EL PASO COUNTY GRADING AND EROSION CONTROL PLAN CHECKLIST

EPC Project Number: _____

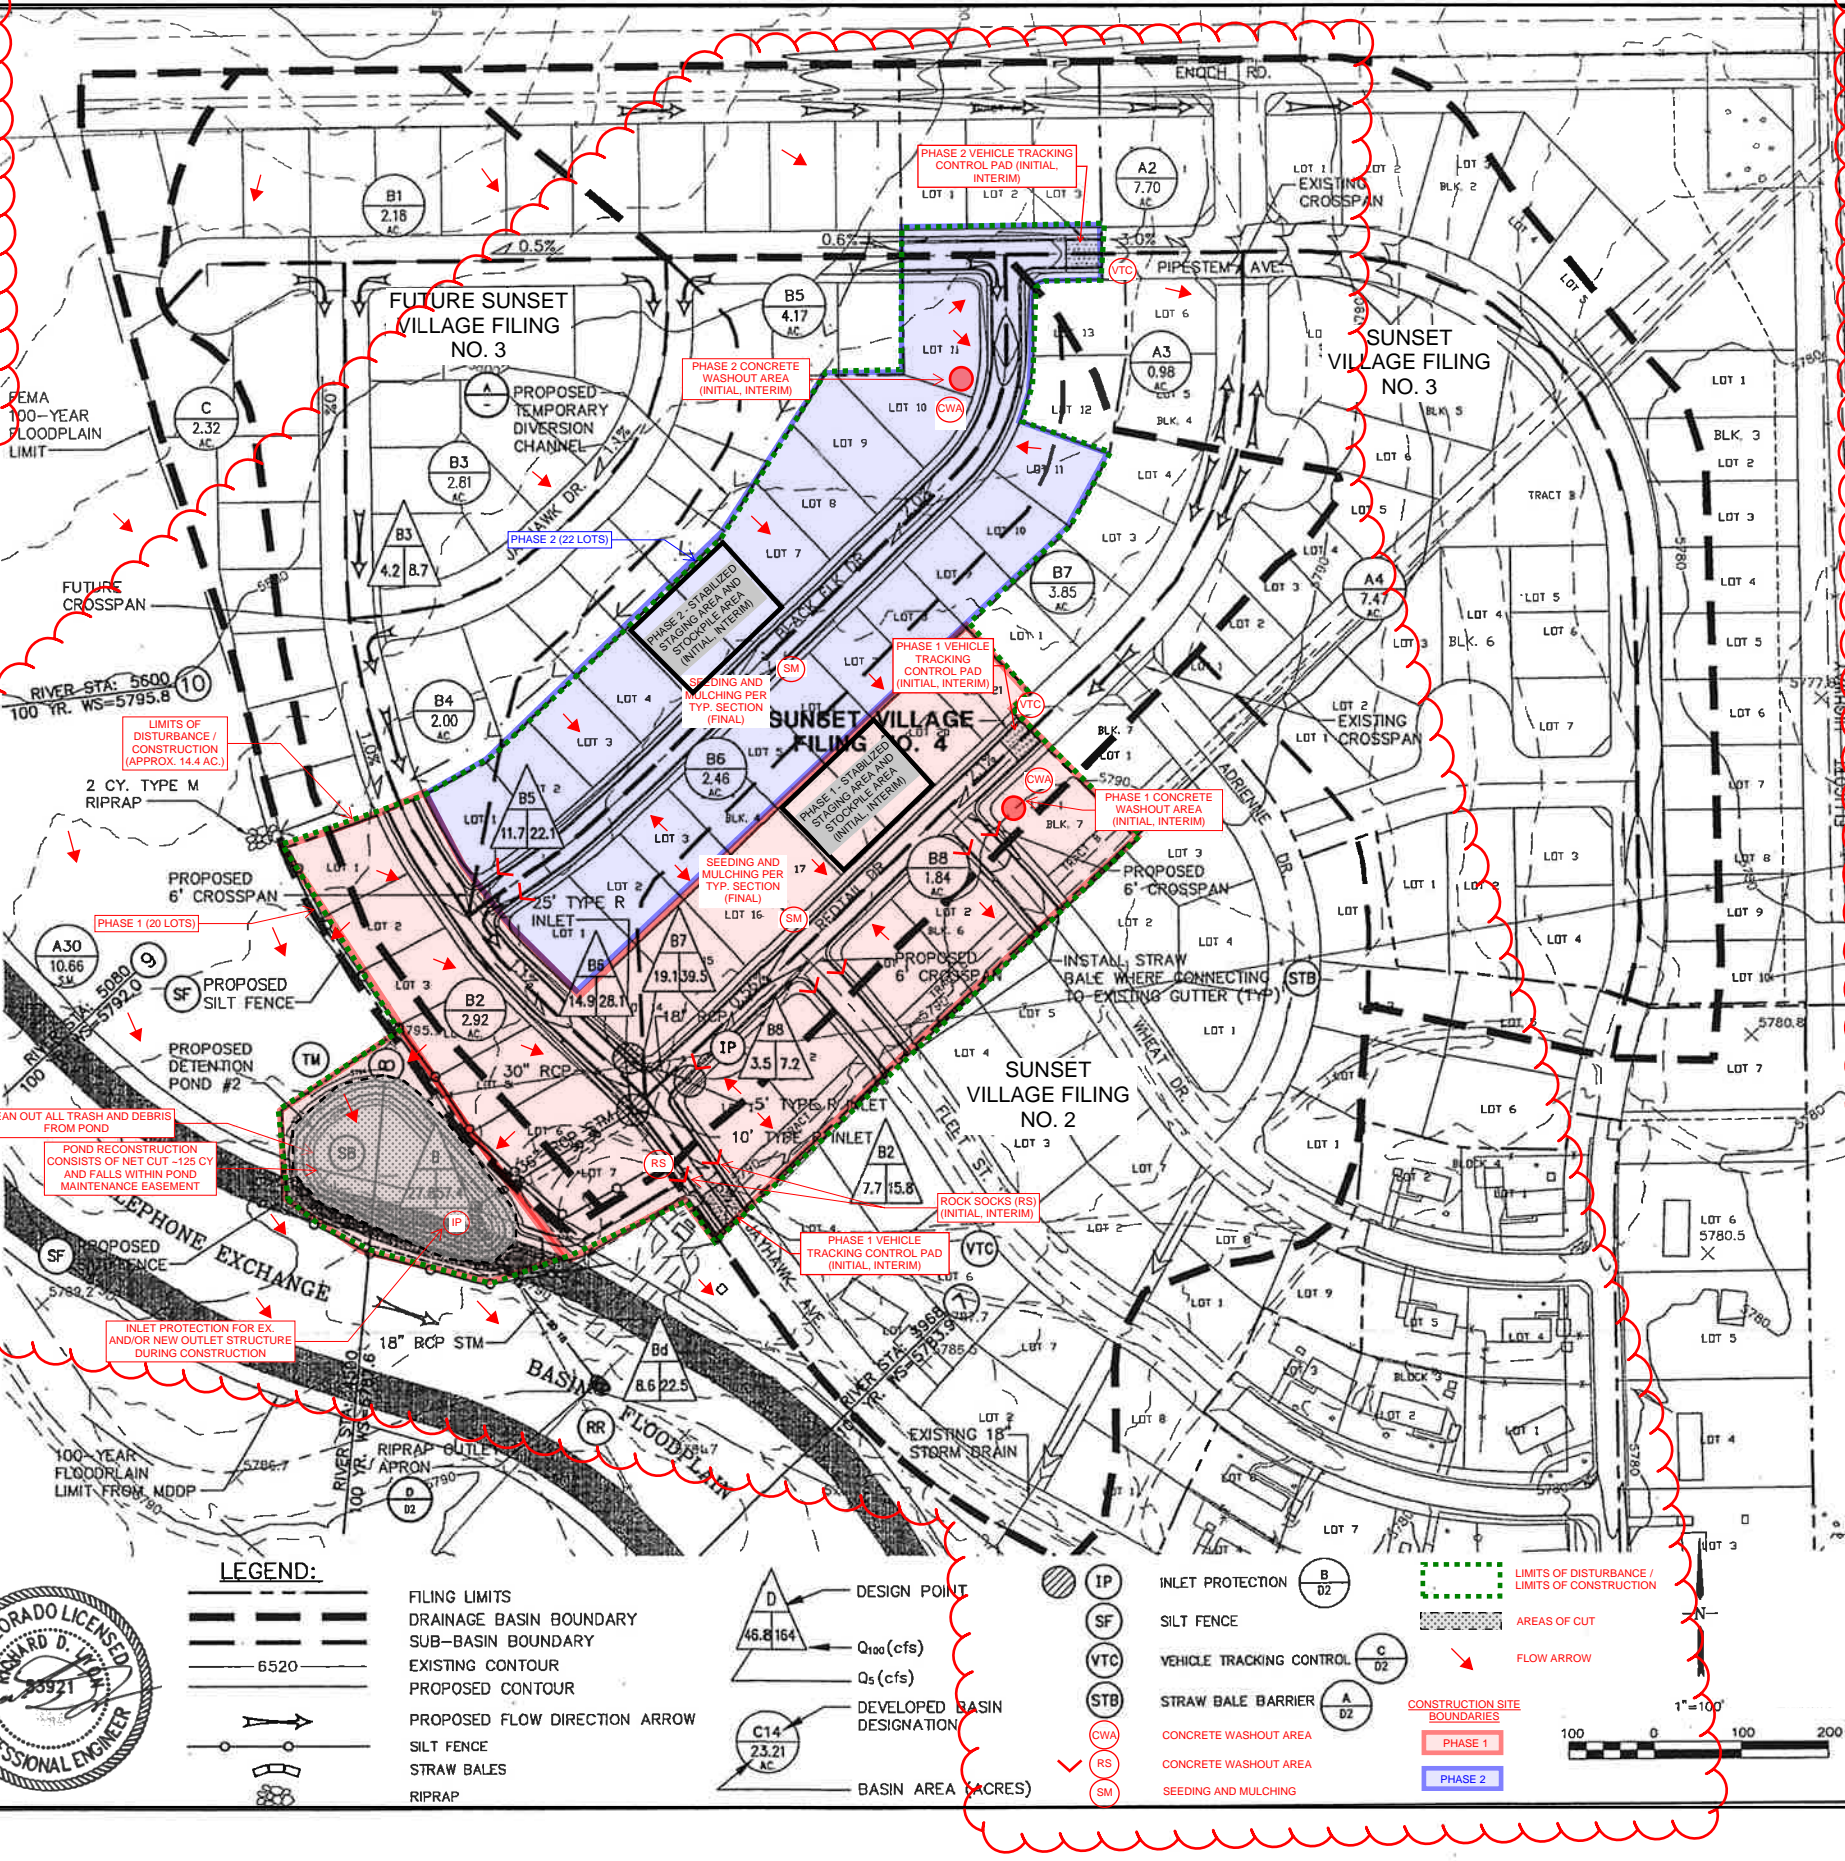
l	Existing and proposed contours 2 feet or less (except for hillside)		Y
m	Limits of disturbance delineating all anticipated areas of soil disturbance show on plans and legend		N
n	Identify and protect areas outside of the construction site boundary with existing fencing, construction fencing or other methods as appropriate		Y
o	Off-site grading clearly shown and called out		N/A?
p	Areas of cut and fill identified		N
q	Conclusions from soils/geotechnical report and geologic hazards report incorporated in grading design (slopes, embankments, materials, mitigation, etc.)		Y
r	Proposed slopes steeper than 3:1 with top and toe of slope delineated. Erosion control blanketing or other protective covering required Label/show on plans if applicable.		N
s	Stormwater flow direction arrows Show more arrows to include lots. Currently arrows only shown in streets.		Y
t	Location of any dedicated asphalt / concrete batch plants		N/A

u	Areas used for staging, storage of building materials, soils (stockpiles) or wastes. The use of construction office trailers requires PCD permitting show on plans and/or notate on plans as applicable.		N
v	All proposed temporary construction control measures, structural and non-structural. Temporary construction control measures shall be identified by phase of implementation to include "initial," "interim," and "final" or shown on separate phased maps identifying each phase Notate on plans		N
w	Vehicle tracking provided at all construction entrances/exits. Construction fencing, barricades, and/or signage provided at access points not to be used for construction Revise location on plans as needed.		N
x	Temporary sediment ponds provided for disturbed drainage areas greater than 1 acre

Applicant	EPC
y	Dewatering operations to include locations of diversion, pump and discharge(s) as anticipated at time of design		N/A?
z	All proposed temporary construction control measure details. Custom or other jurisdiction's details used must meet or exceed EPC standards See comment on VTC detail.		N
aa	Any off-site stormwater control measure proposed for use by the project and not under the direct control or ownership of the Owner or Operator		N/A
bb	Existing and proposed permanent storm water management facilities, including areas proposed for stormwater infiltration or subsurface detention		Y
cc	Existing and proposed easements (permanent and construction) including required off-site easements Show pond maintenance easement on plans.		N
dd	Retaining walls (not to be located in County ROW unless approved via license agreement). Design by P.E. and building permit from Regional Building Department required for walls greater than or equal to 4 feet in height, series of walls, or walls supporting a surcharge		N/A?
